SUBMISSION FROM BIKES BOTANY BAY SSI-9714: BOTANY RAIL DUPLICATION

13th November 2019.

Figure 1.1 Botany Rail Duplication location

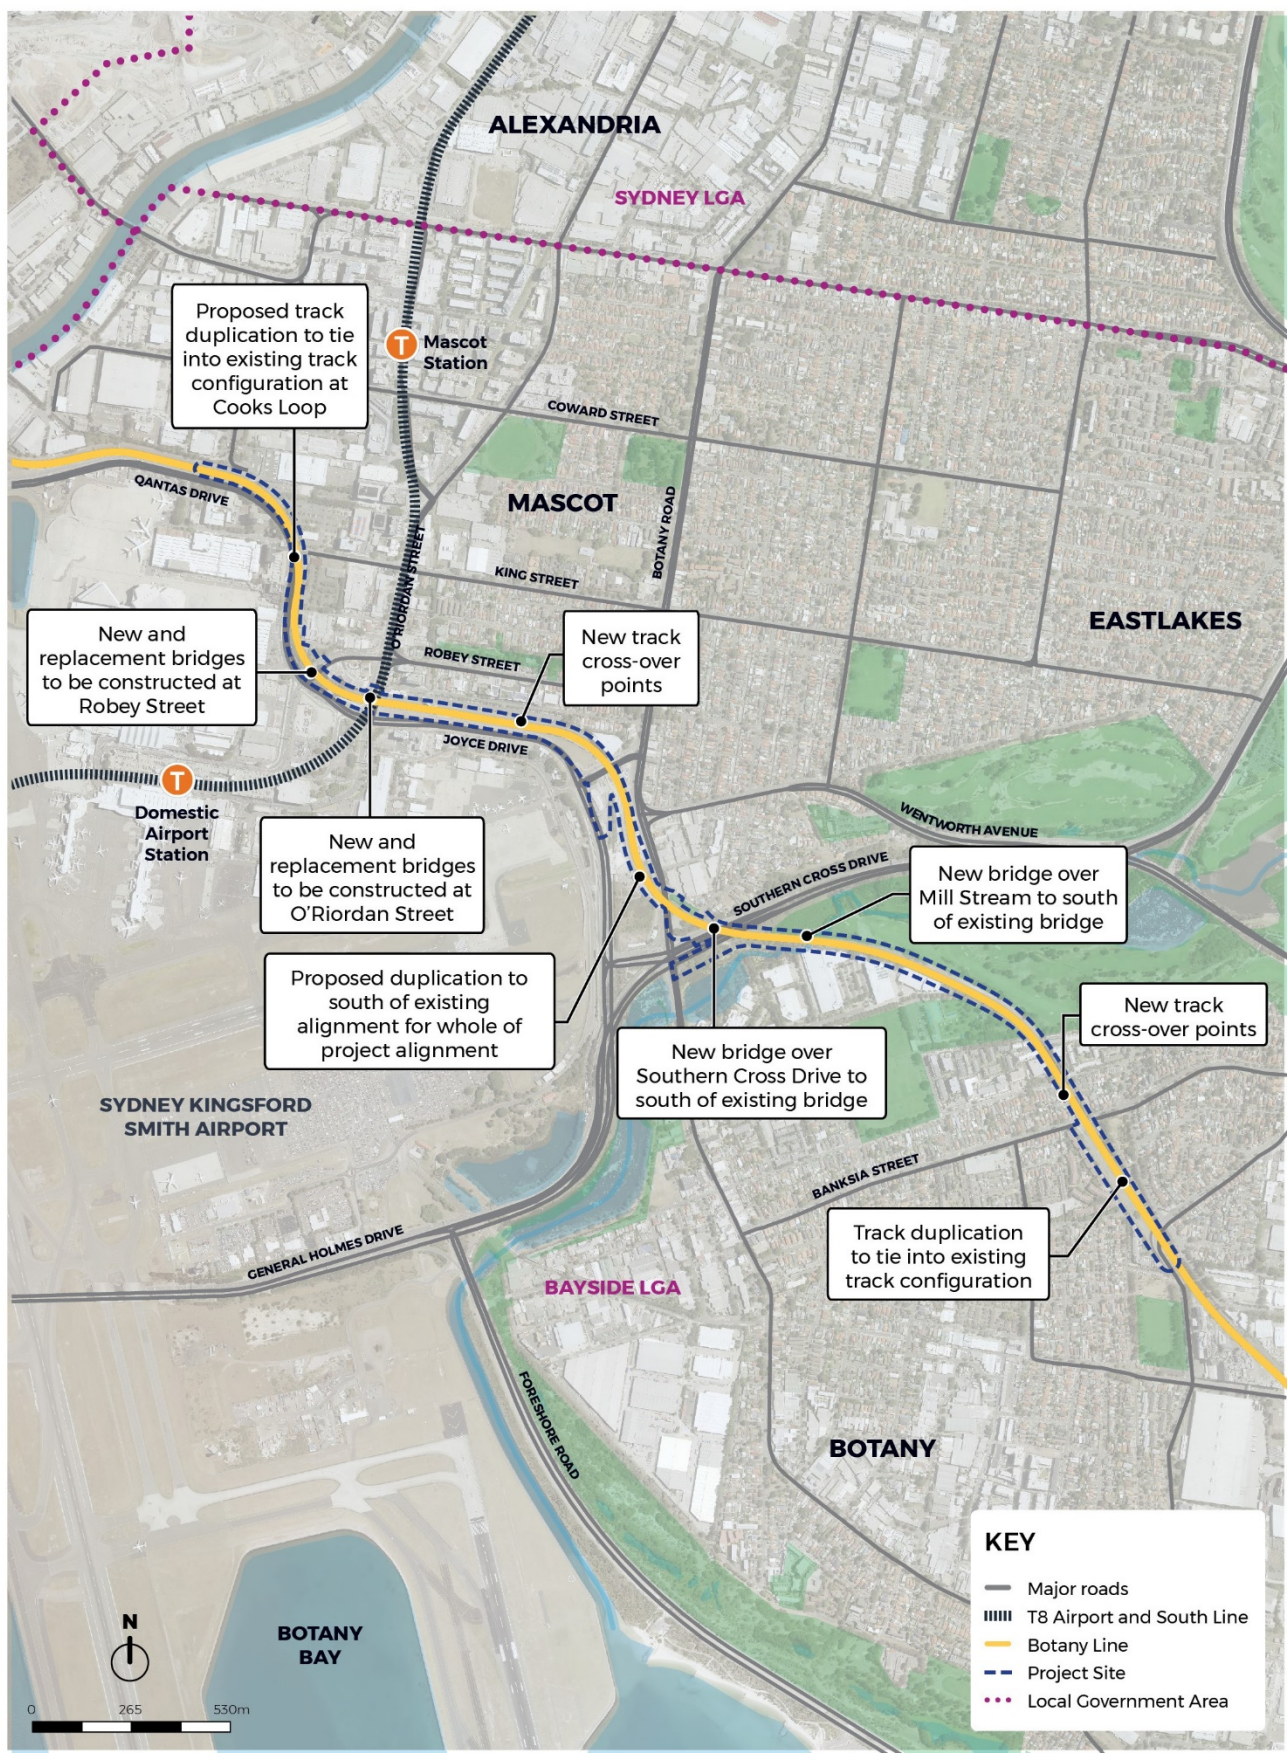
To illustrate the low level of understanding of the needs of the area I direct NSW Planning to the following figure contained in the proponent's Hazard and Risk Analysis:

The third port terminal is not shown. This project included the reclamation of 63 ha of Botany Bay, took out Botany's only beach and Penrhyn Spit and canoeing and windsurfing and other small craft recreation. Readers of the EIS would mistakenly think that residents around this area still had access to the beach and waters when this is not the case. Only fishers who can afford boats have access. What remains of the beach is a highly eroded gross pollutant trap.
